A103 Memorandum

Date:	8 August 2019			
Project Name:	Newcastle Courthouse Redevelopment Nihon University			
Project No:	auncl-17-0347			
Reference:	17-0347 memo 27 – 08.08.2019			
Page	1 of 6			
To:	Copy	Company	Attention	Circulation
✓		NSW Department of Planning & Environment	Megan Fu	Megan.Fu@planning.nsw.gov.au
	✓	City Plan	Murray Blackburn-Smith	murraybs@cityplan.com.au
	✓	Azusa Sekkei Co Ltd	Jun Yokobori	yokobori1482@azusasekkei.co.jp
	✓	dwp Australia Pty Ltd	Ed Clode	edward.c@dwp.com
	✓	dwp Australia Pty Ltd	Katherine Daunt	Katherine.d@dwp.com

27 SSD-9787 Nihon University Newcastle Campus – National Trust and Heritage Council Response

DRAWING:	<b>LANDSCAPE PLAN - 1ST FLOOR</b>
PROJECT NUMBER:	1691
SHEET:	05 OF 07

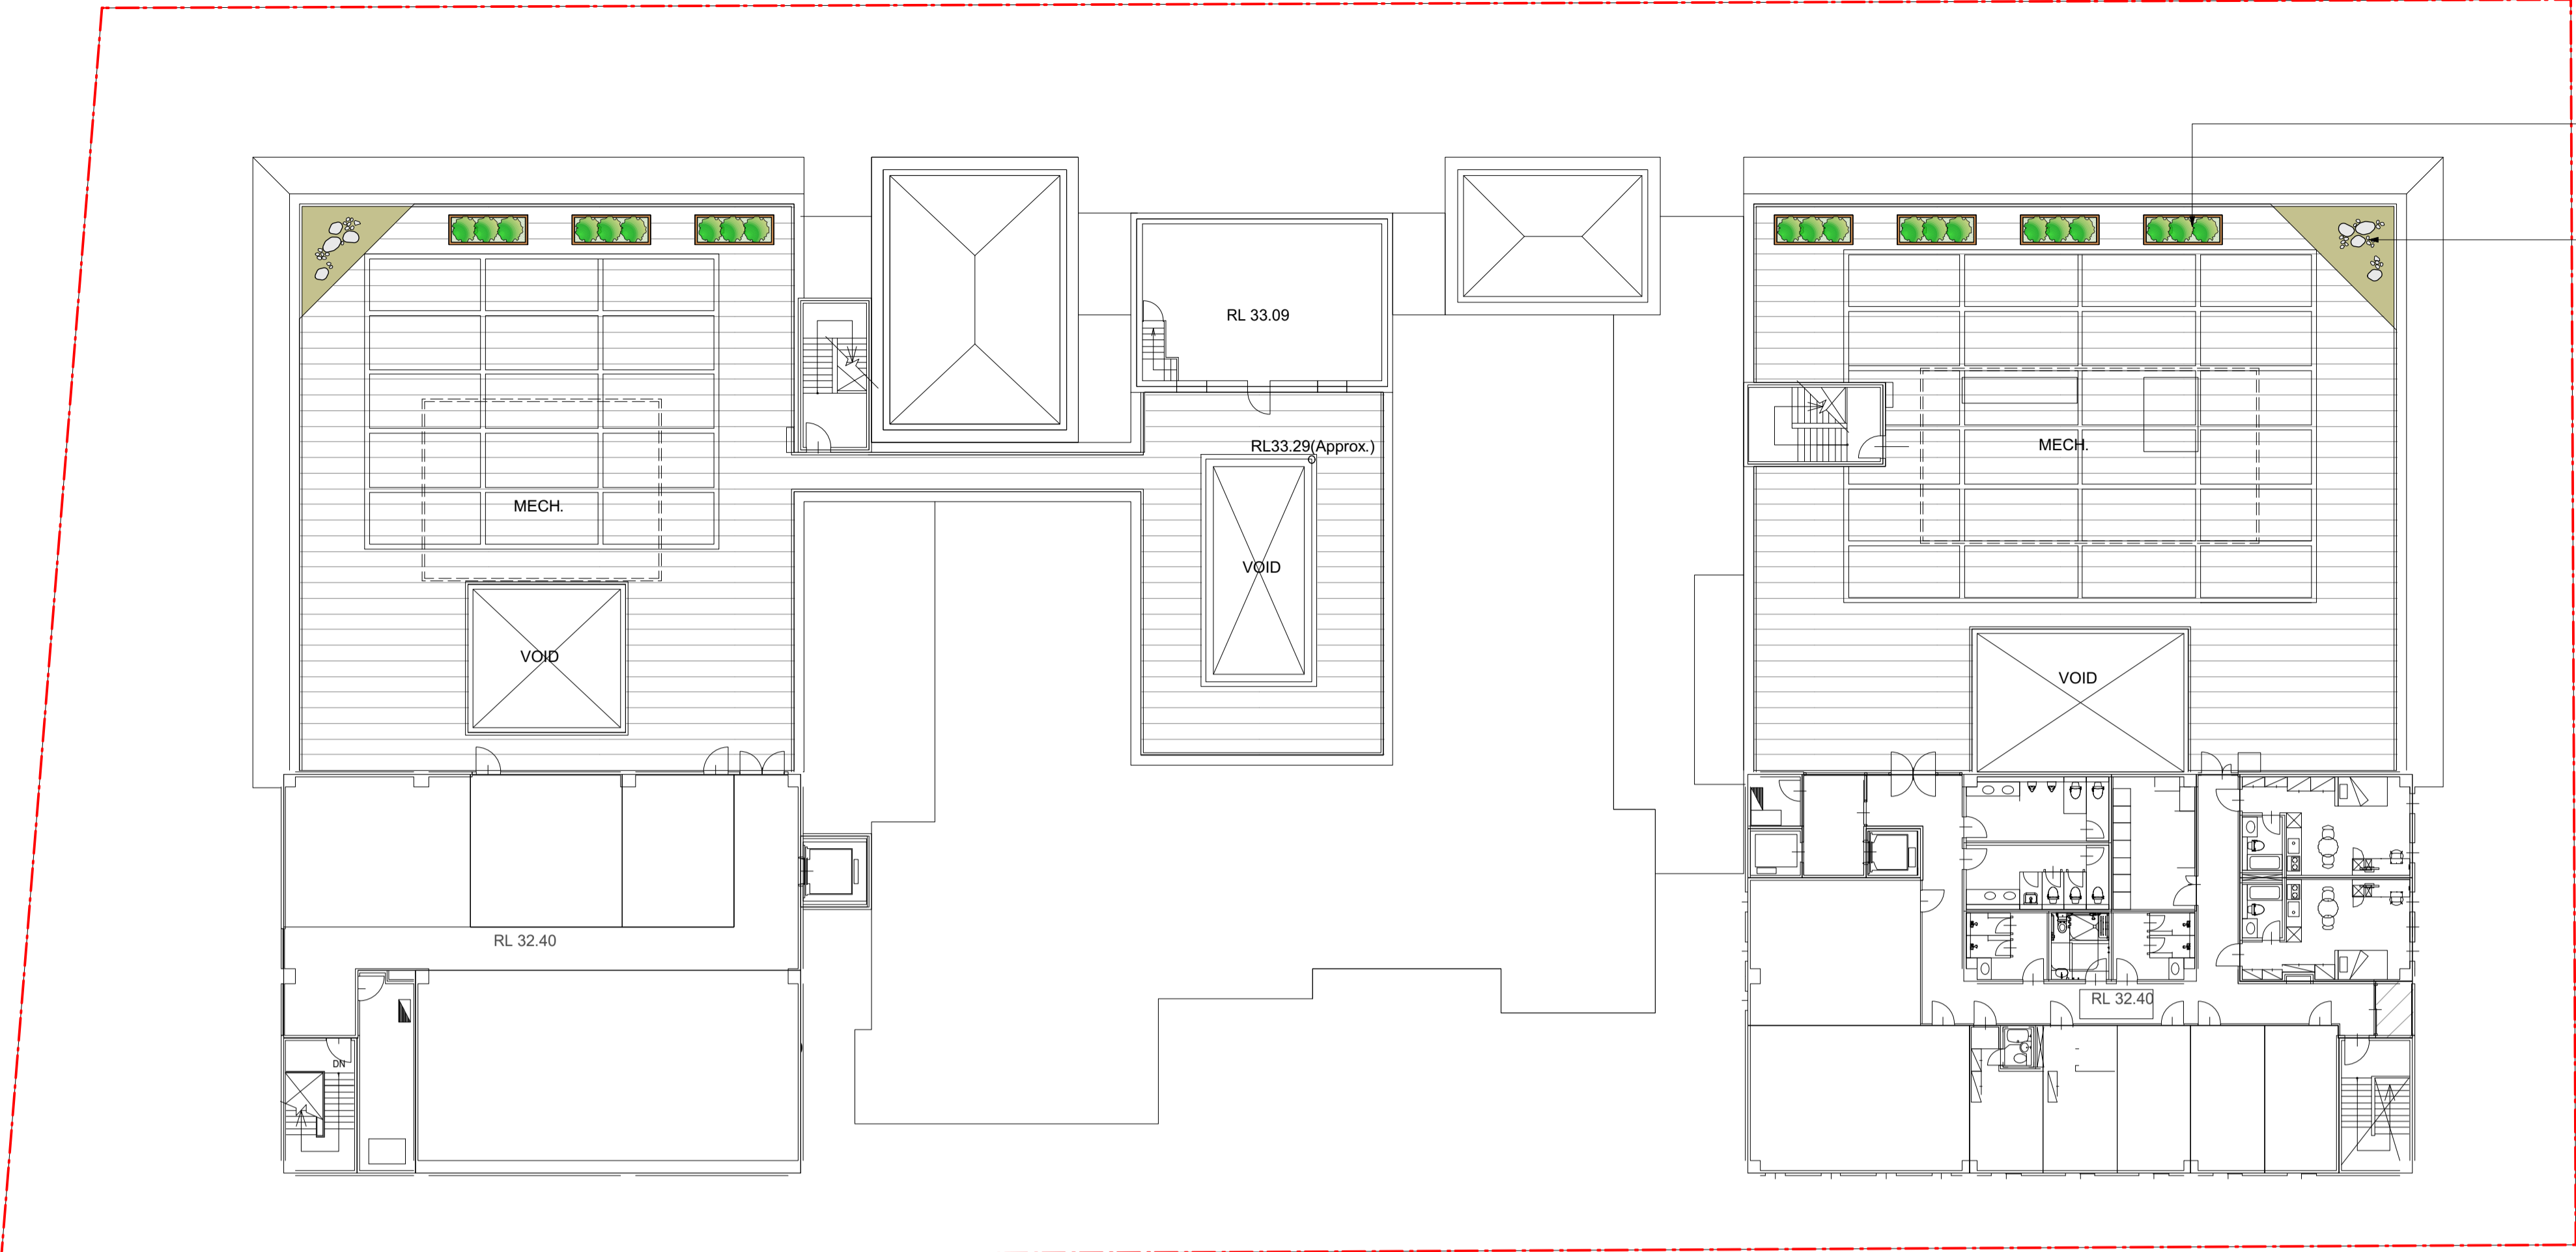
The 'stone plinth' is one of several 'heritage' water bubblers in the The Hill Heritage Conservation Area and should be made operable and retained in situ for public amenity at the Bolton-Church Street intersection instead of relocated to a courtyard.

The existing "stone plinth" water bubbler is to remain on the footpath in its current location and state of operation. There is no intention for the stone plinth water bubbler to be relocated or altered. Please refer to Landscape drawing LP05_Rev C "LANDSCAPE PLAN - 1ST FLOOR" where it clearly notes on this drawing that the plinth is retained.
